CITY OF ALBUQUERQUE

**RE: O'Niell's Addition & Remodel, 4310 Central Ave SE
Request For Permanent Certification of Occupancy
Engineer's Stamp Date 3-27-2014 (K17D100)
Certification Stamp Date 8-13-2014**

**RE: O'Niell's Addition & Remodel, 4310 Central Ave SE
Grading and Drainage Plan
Engineer's Stamp Date 3-27-2014 (K17D100)**

GRADING AND DRAINAGE PLAN

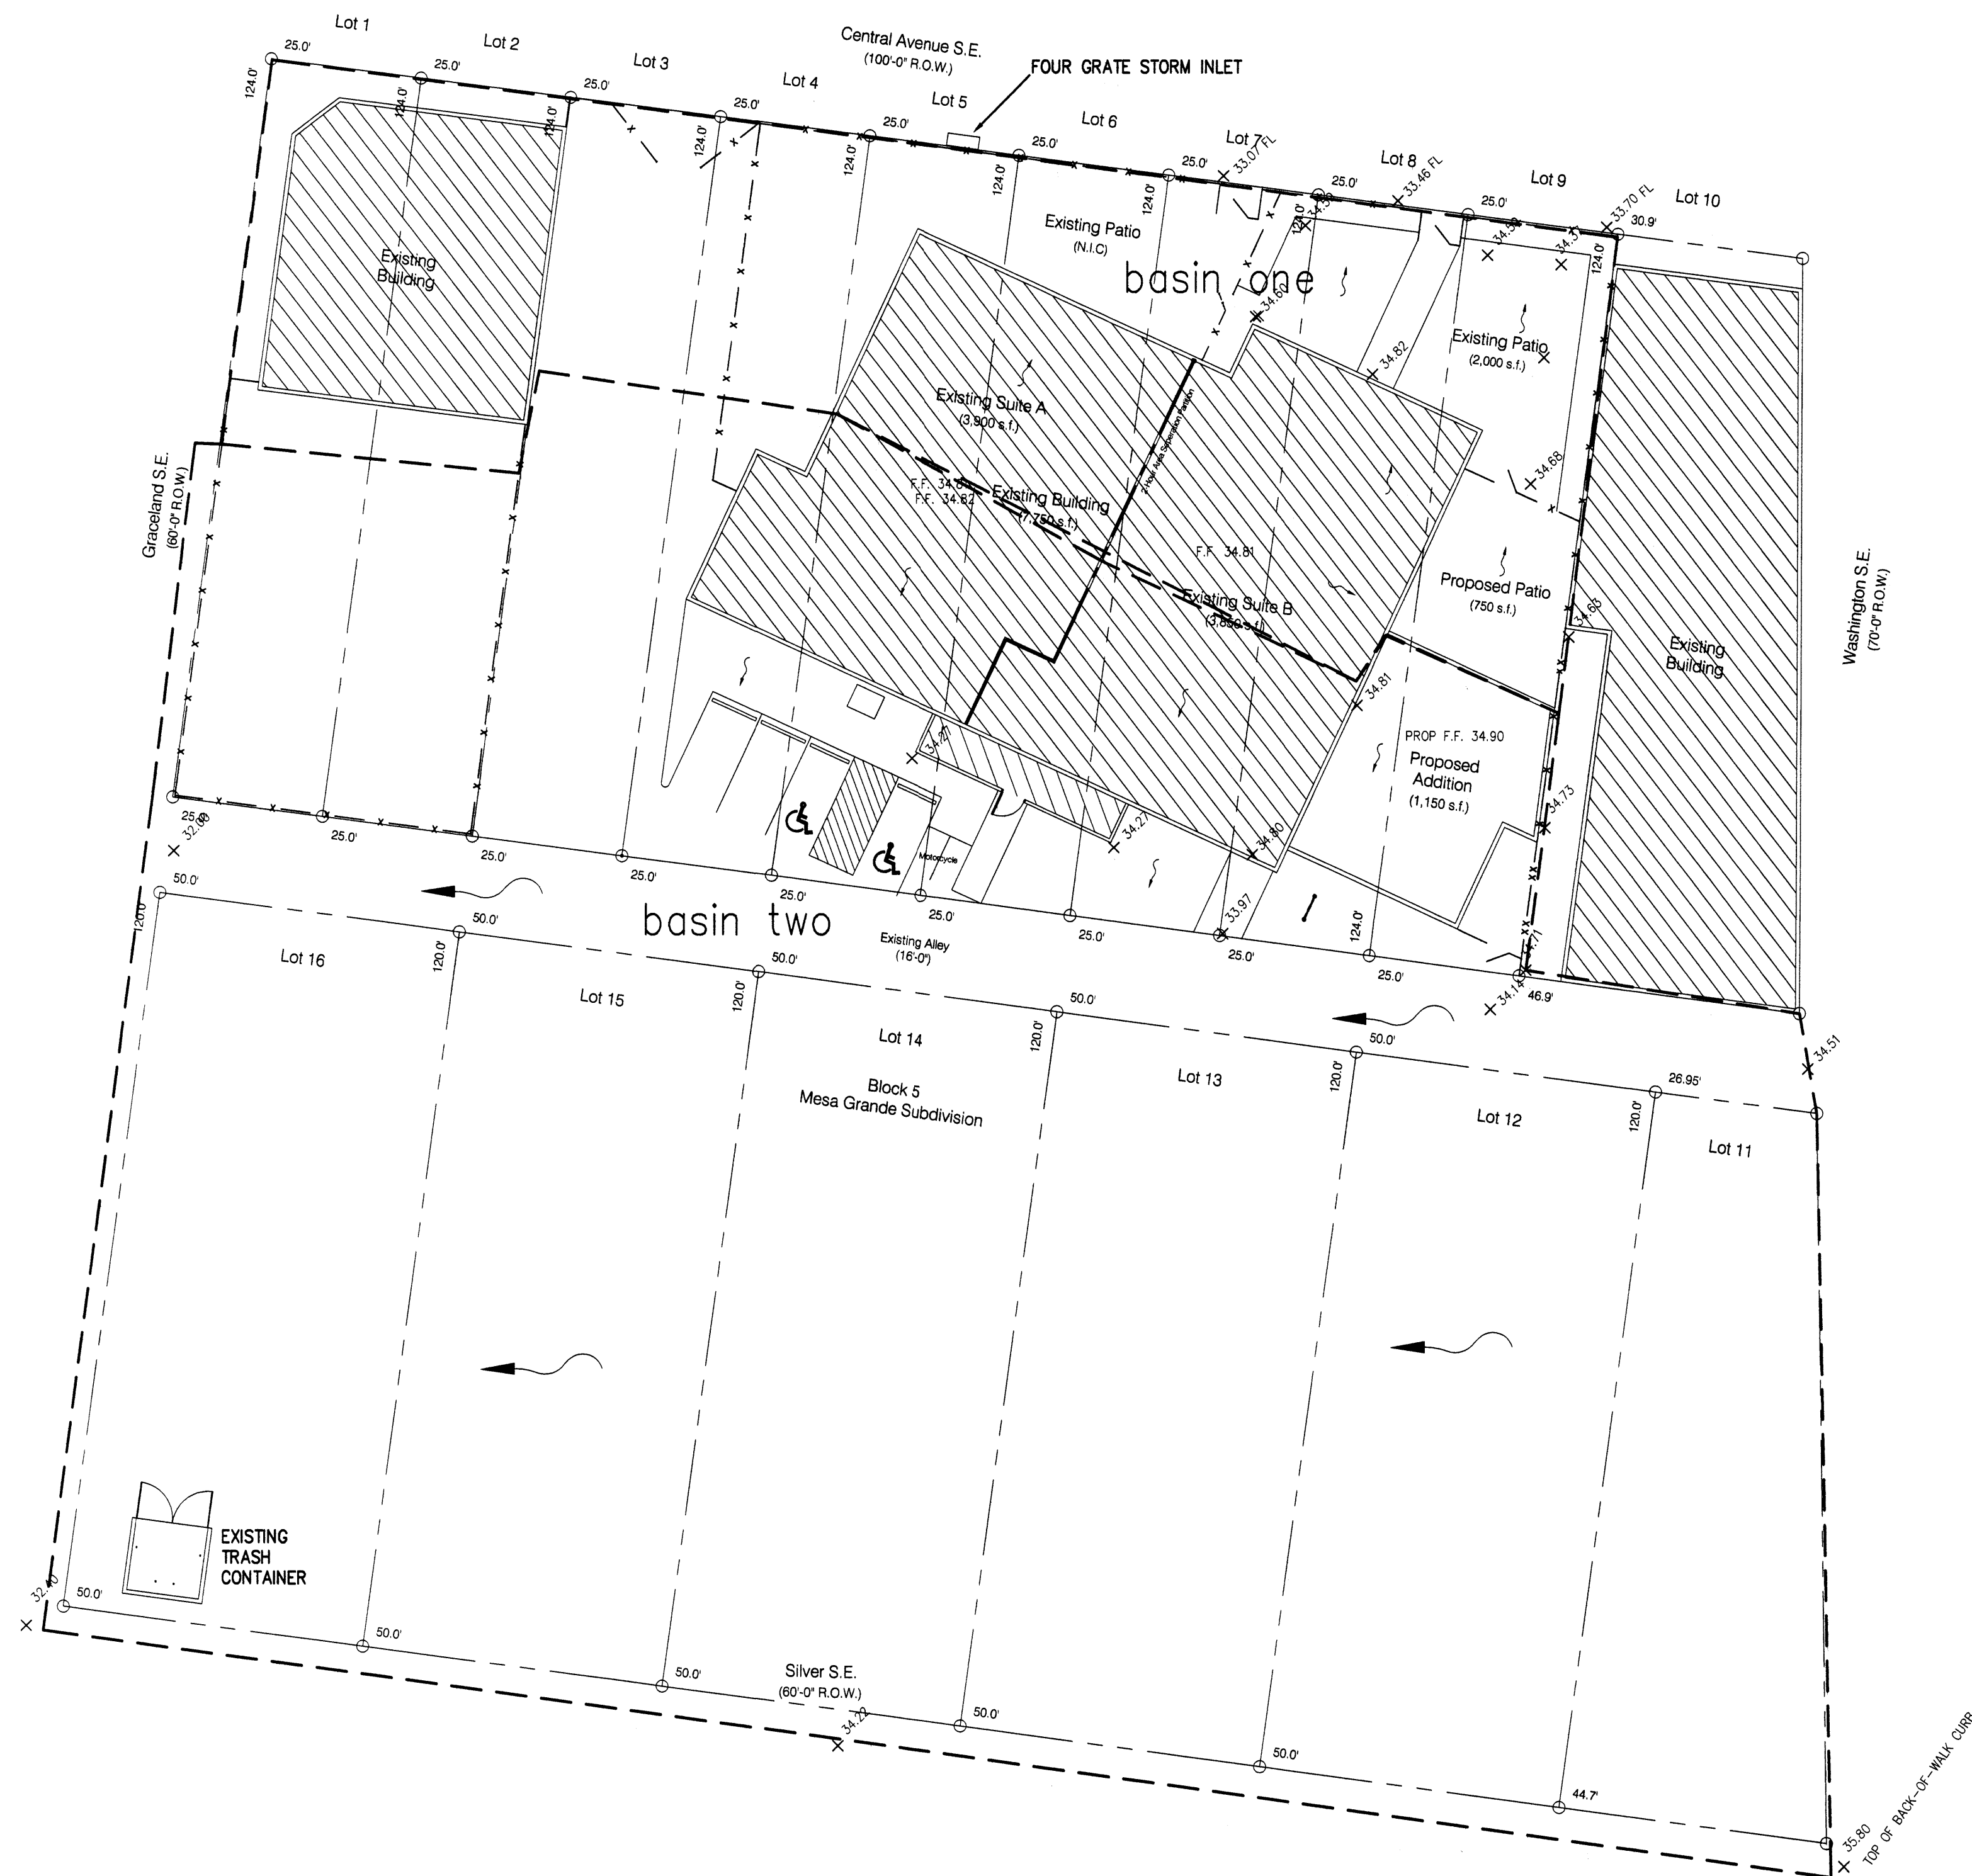
Based upon the information provided in your submittal received 3-27-14, the above referenced plan is approved for Building Permit and SO-19 Permit based on the following condition:

- Plat indicates there is a cross-lot drainage easement through replatted Lot 4A prior to Certificate of Occupancy.
